OUT17/8841

**Moorebank Precinct East Stage 2 (SSD 7628)
Comment on the Environmental Impact Statement (EIS)**

I refer to the email of 13 December 2016 to the Department of Primary Industries (DPI) in respect to the above matter. Comment has been sought from relevant divisions of DPI. Views were also sought from NSW Department of Industry - Lands that are now a division of the broader Department and no longer within NSW DPI. Any further referrals to DPI can be sent by email to landuse.enquiries@dpi.nsw.gov.au.

Project	MOOREBANK PRECINCT EAST (MPE) STAGE 2
Title	GENERAL ARRANGEMENT PLAN

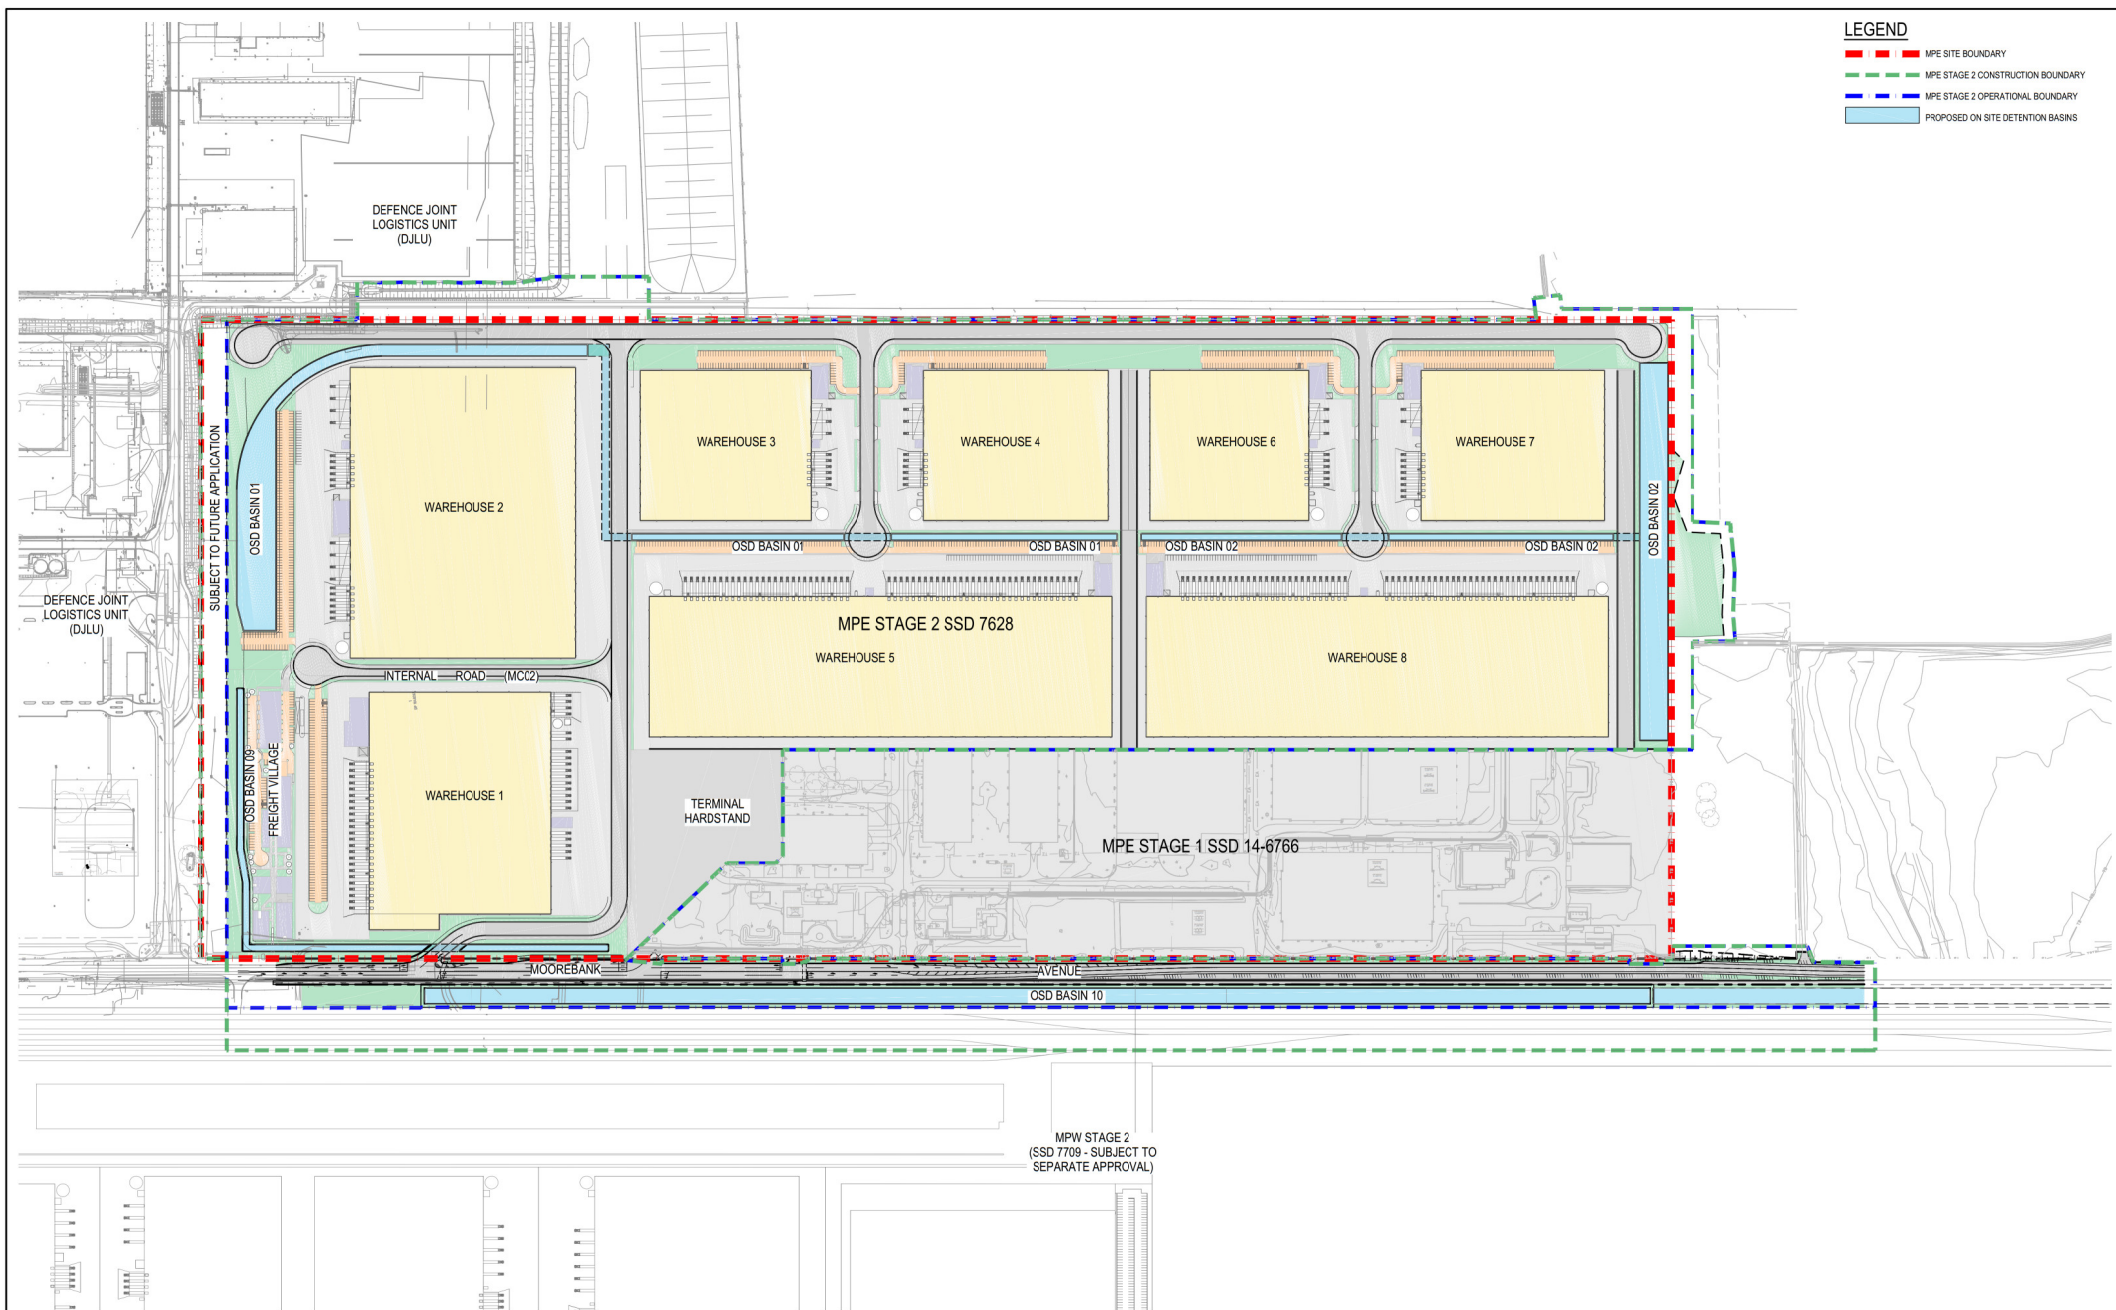
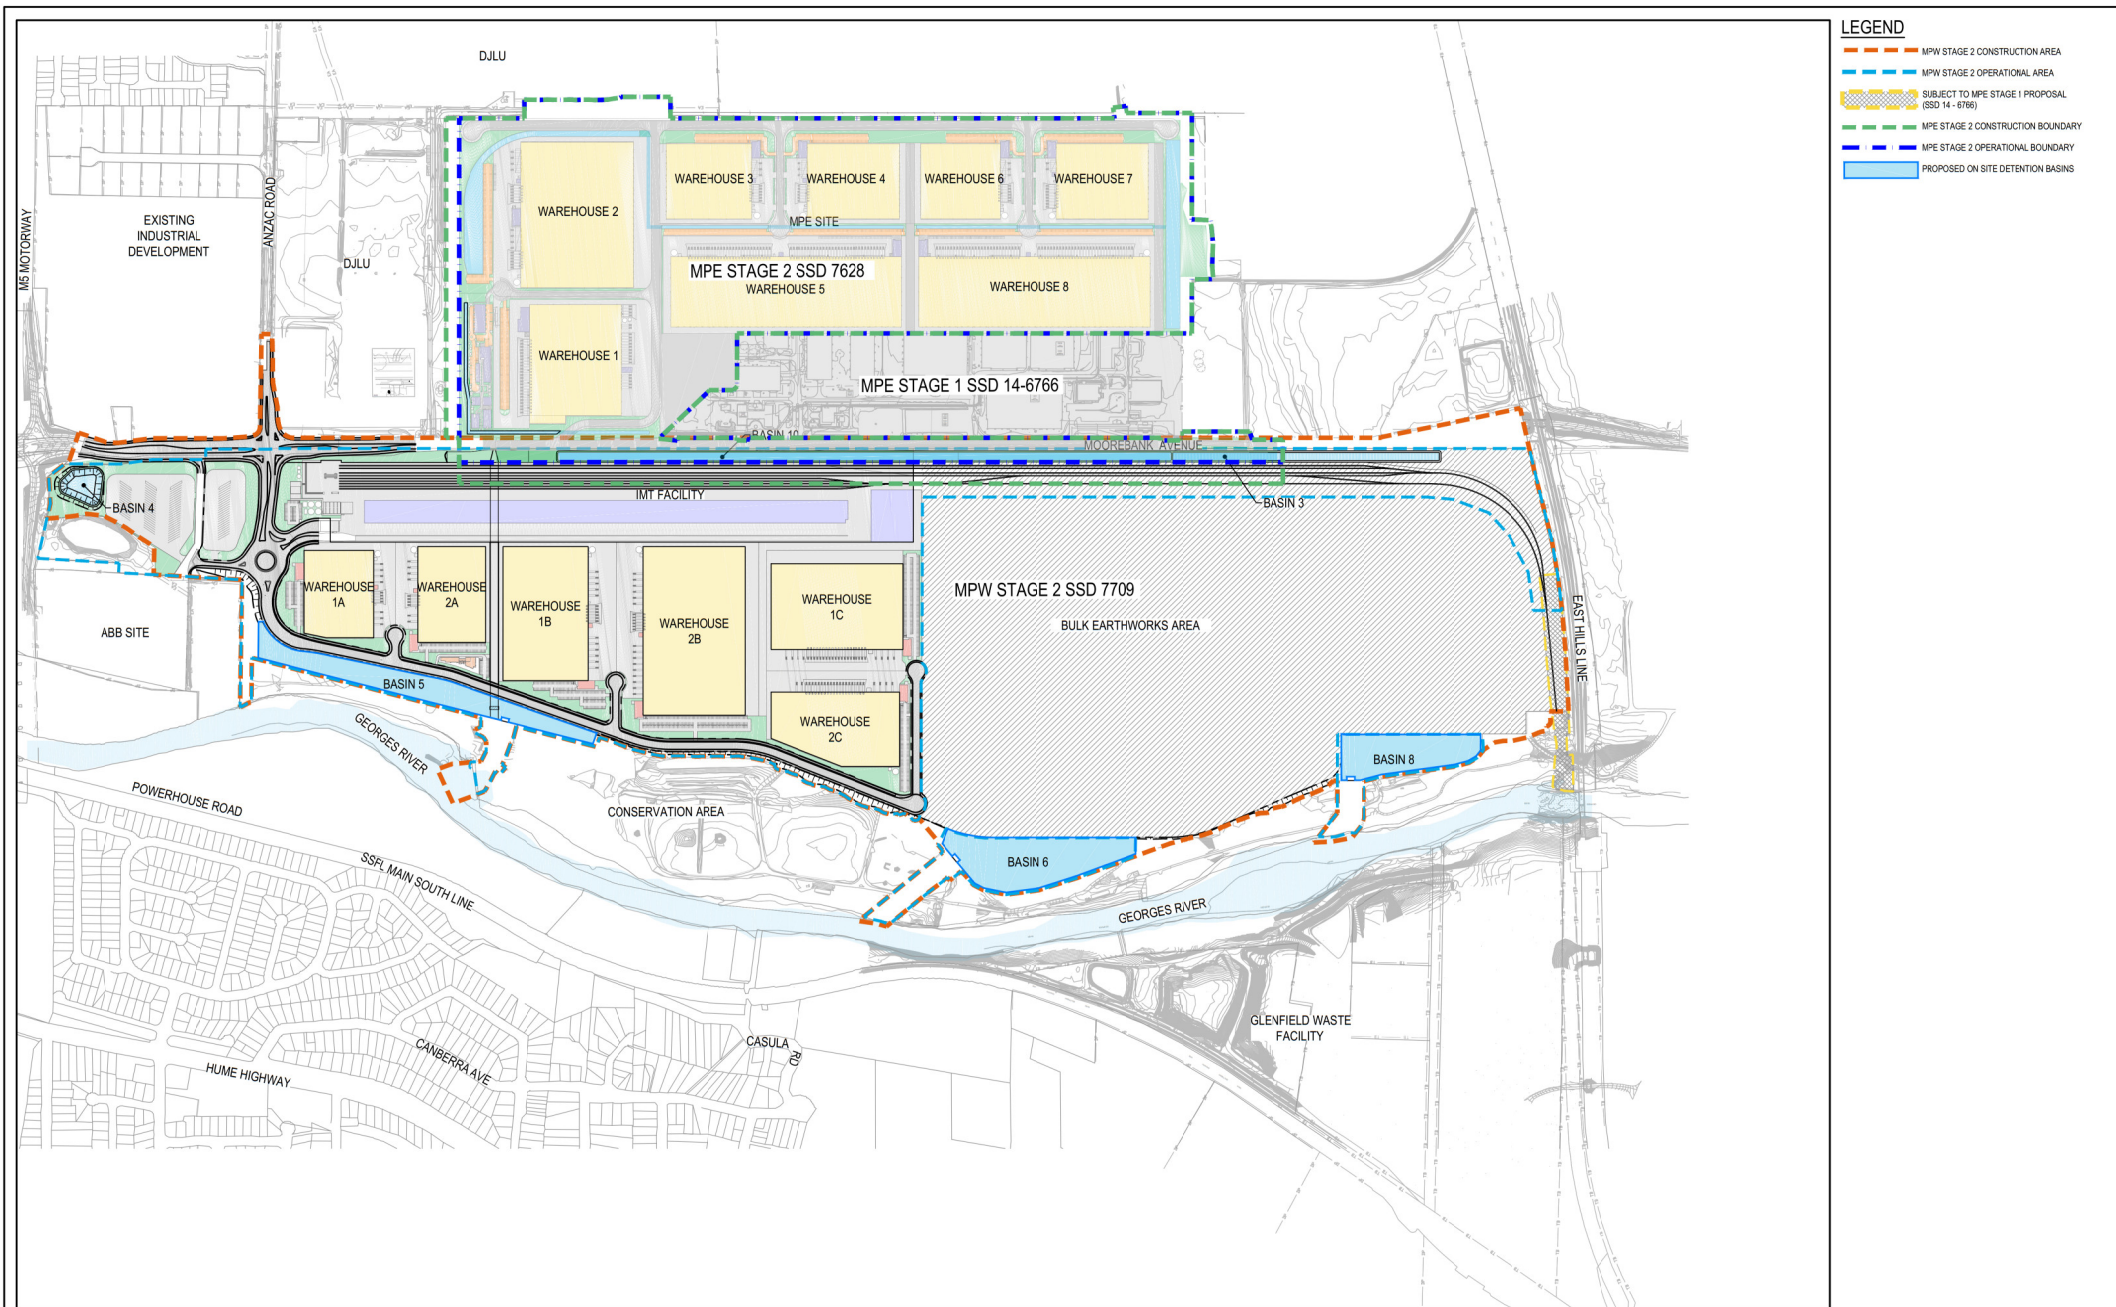
- The proponent should provide details on the proposed drainage works to the south of the MPE site, including:
 - Clarification on whether the swale needs to feed into Anzac Creek or whether it can be located and operate outside the riparian corridor to minimise impacts to the creek;

- a description of the proposed drainage works;
 - a description of the proposed temporary side track crossings;
 - representative drawings of the drainage swale and temporary crossing structures;

- a scaled map which clearly shows the location of:
 - Anzac Creek
 - top of bank
 - the 30 m wide riparian corridor along either side of the creek
 - existing native vegetation within the riparian corridor

- the proposed drainage works
 - the proposed temporary side track crossings
 - details on the depth, length and width of the drainage works and how the drainage swale is proposed to feed into the creek, any scour protection works;
